# Rezoning Transportation Analysis

Petition Number: #2022-168

**From:** Jake Carpenter, PE

Date	Description
02-22-23	First Review (TM)

PROJECT:
THE MARQUEE
TAPAS AND LOUNGE

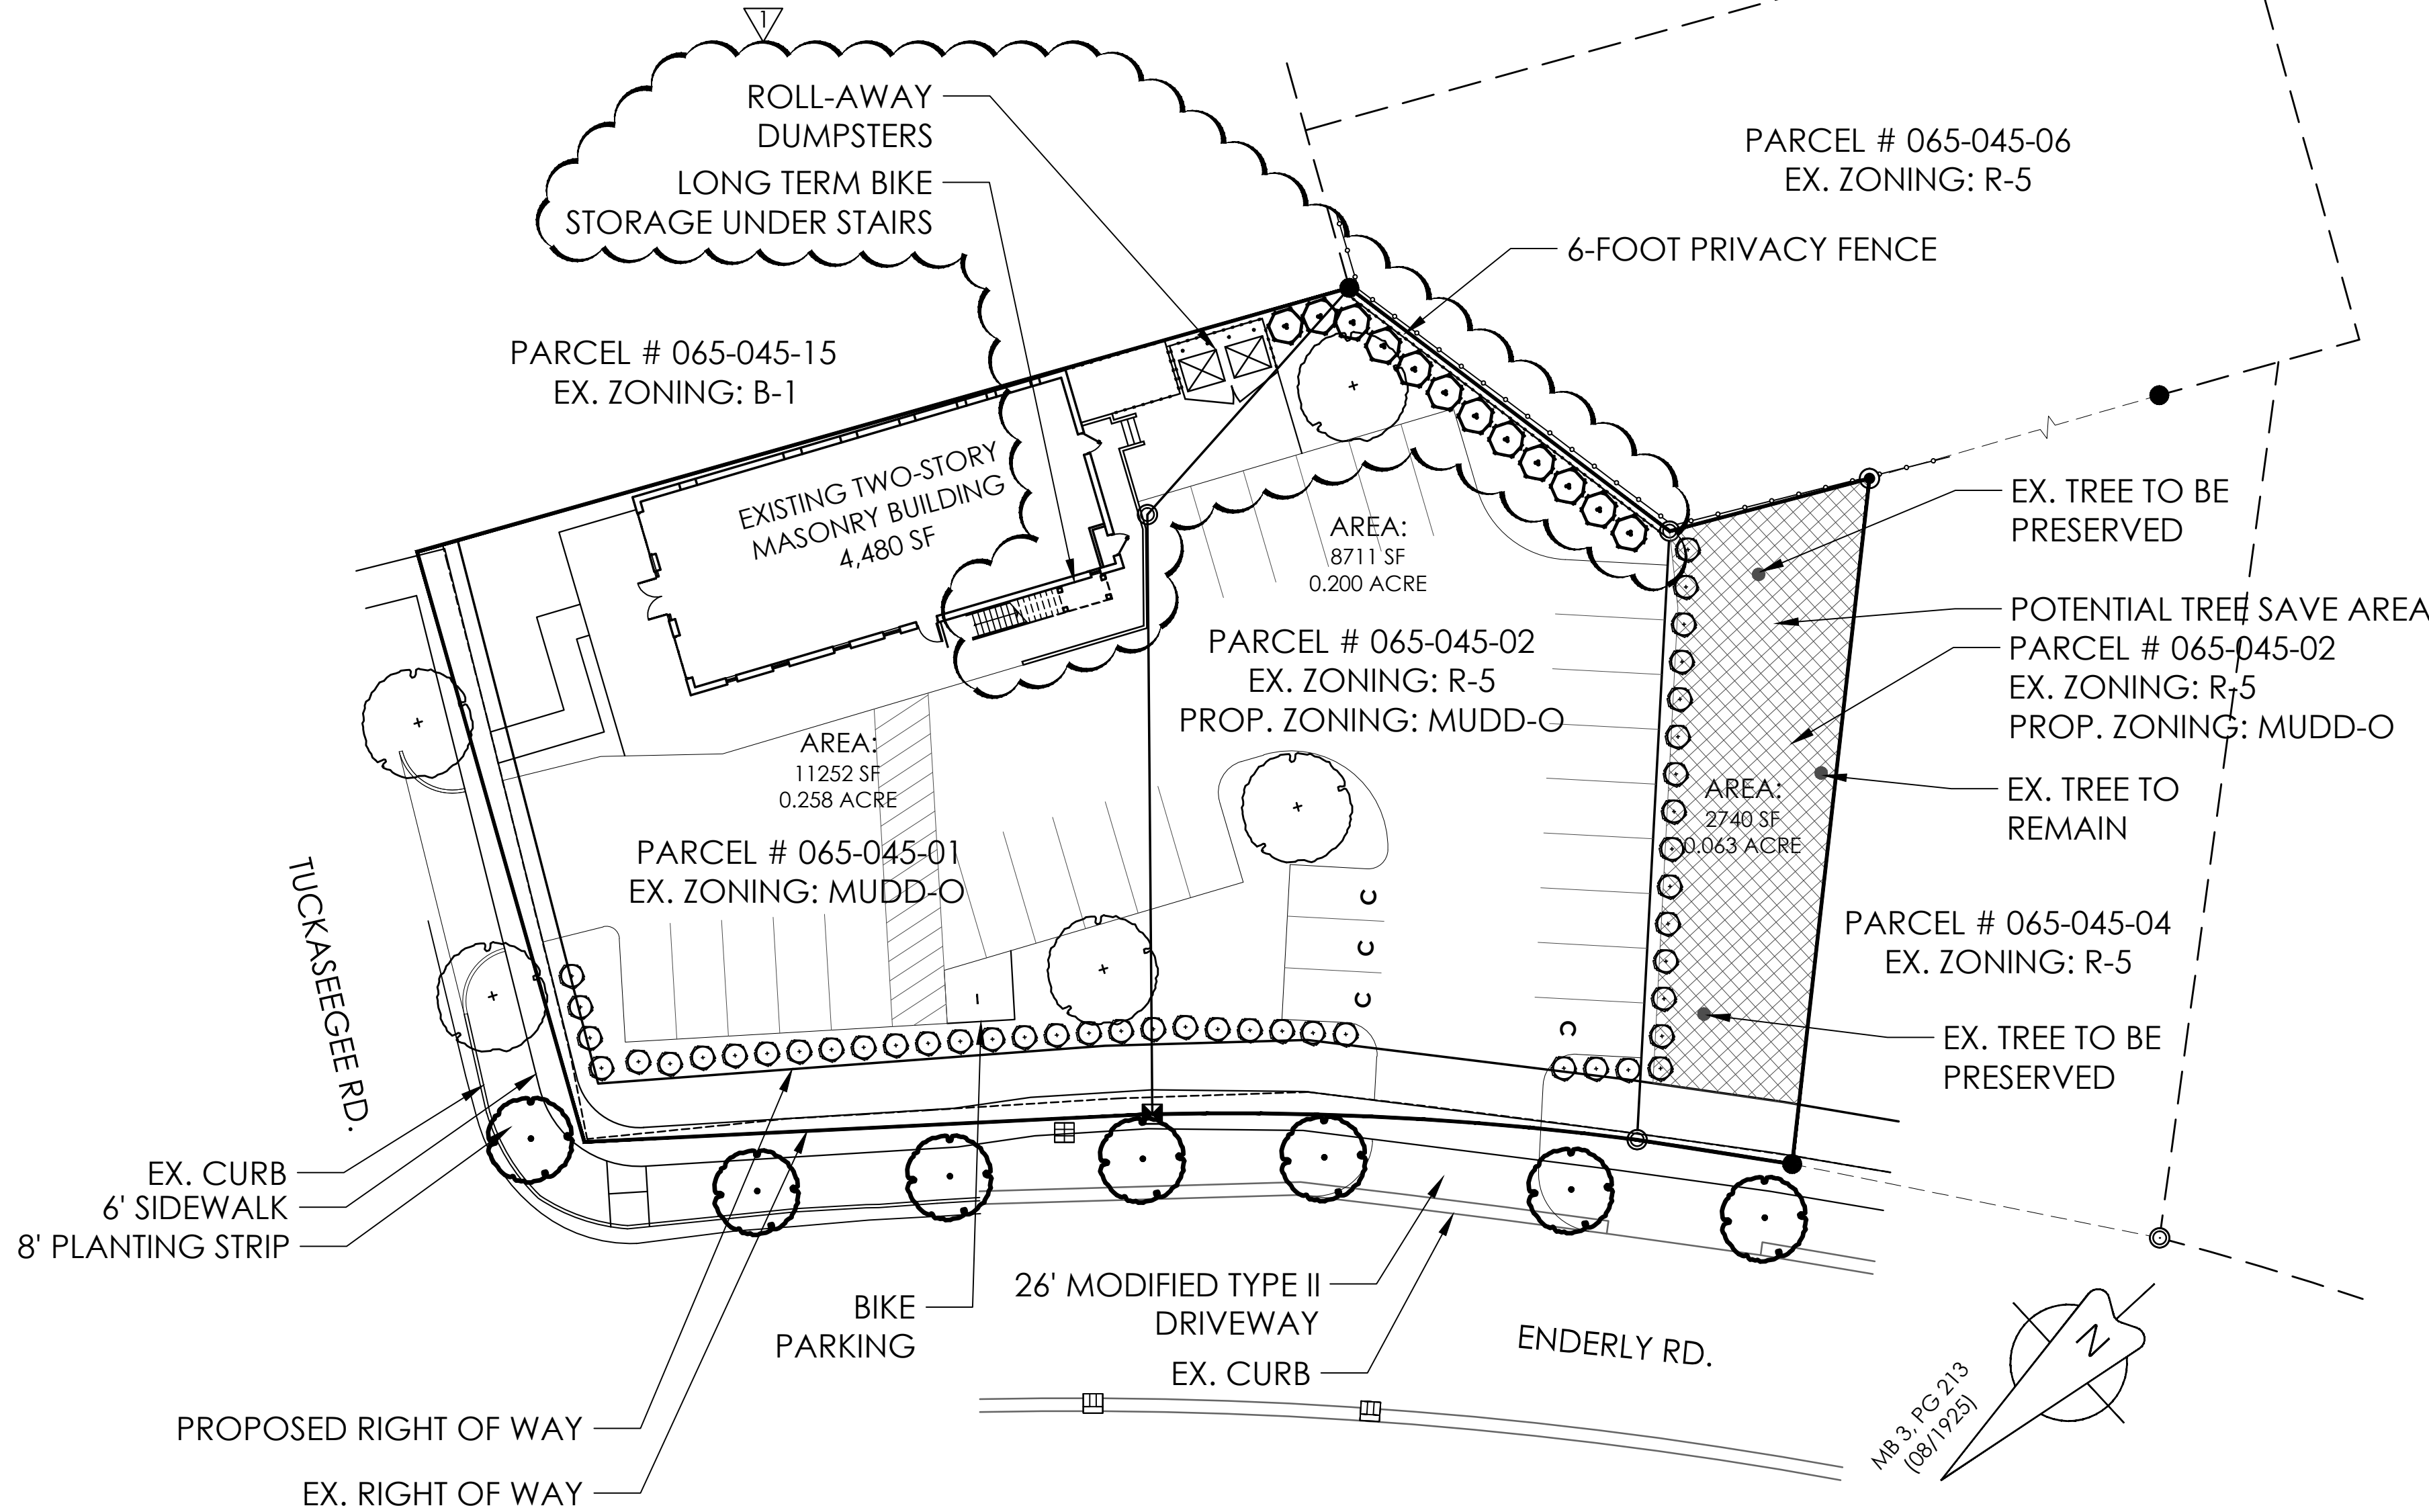
- Tuckaseegee Road:** Location of curb and gutter to be moved to 27 feet from roadway centerline to accommodate the Charlotte Streets Map with a roadway typical section of a 2+ Avenue, Buffered/Separated Bike Lanes. Show future curb line on site plan and dimension plating strip and sidewalk from the future back of curb location.
- Enderly Road:** The future location of curb and gutter is in its existing location.

Label and dimension the curb and gutter from the centerline for each road on the site plan.

- Revise site plan to commit to dedicate 40-feet of right-of-way from the Tuckaseegee Road centerline. The site plan shall label and dimension the right-of-way from the road centerline.
- Revise site plan to commit to dedicate 36-feet of right-of-way from the Enderly Road centerline. The site plan shall label and dimension the right-of-way from the road centerline.
- CDOT REQUEST:** that site plan and conditional note(s) revisions are made to commit to construct an 8-foot planting strip, and 8-foot sidewalk on Tuckaseegee Road to match the overall city plan for this street section per Charlottes Streets Map. The site plan shall label and dimension both items from the future back of curb and gutter. The wider sidewalk also meets the Charlotte WALKS Policy

6. Add a conditional note specifying "A Right-of-Way Encroachment Agreement is required for the installation of any non-standard item(s) (irrigation systems, decorative concrete pavement, brick pavers, etc.) within a proposed/existing City-maintained street right-of-way by a private individual, group, business, or homeowner's/business association. An encroachment agreement must be approved by CDOT prior to construction/installation. Contact CDOT for additional information concerning cost, submittal, and liability insurance coverage requirements."

7. Add a conditional note specifying "the Petitioner shall dedicate and convey in fee simple all rights-of-way to the City before the site's first building certificate of occupancy is issued. CDOT requests rights-of-way set at 2' behind back of sidewalk where feasible."

8. Revise conditional note specifying "All transportation improvements will be approved and constructed before the site's first building certificate of occupancy is issued. The petitioner may phase transportation improvements if said improvements and phasing are explicitly described in site plan notes."
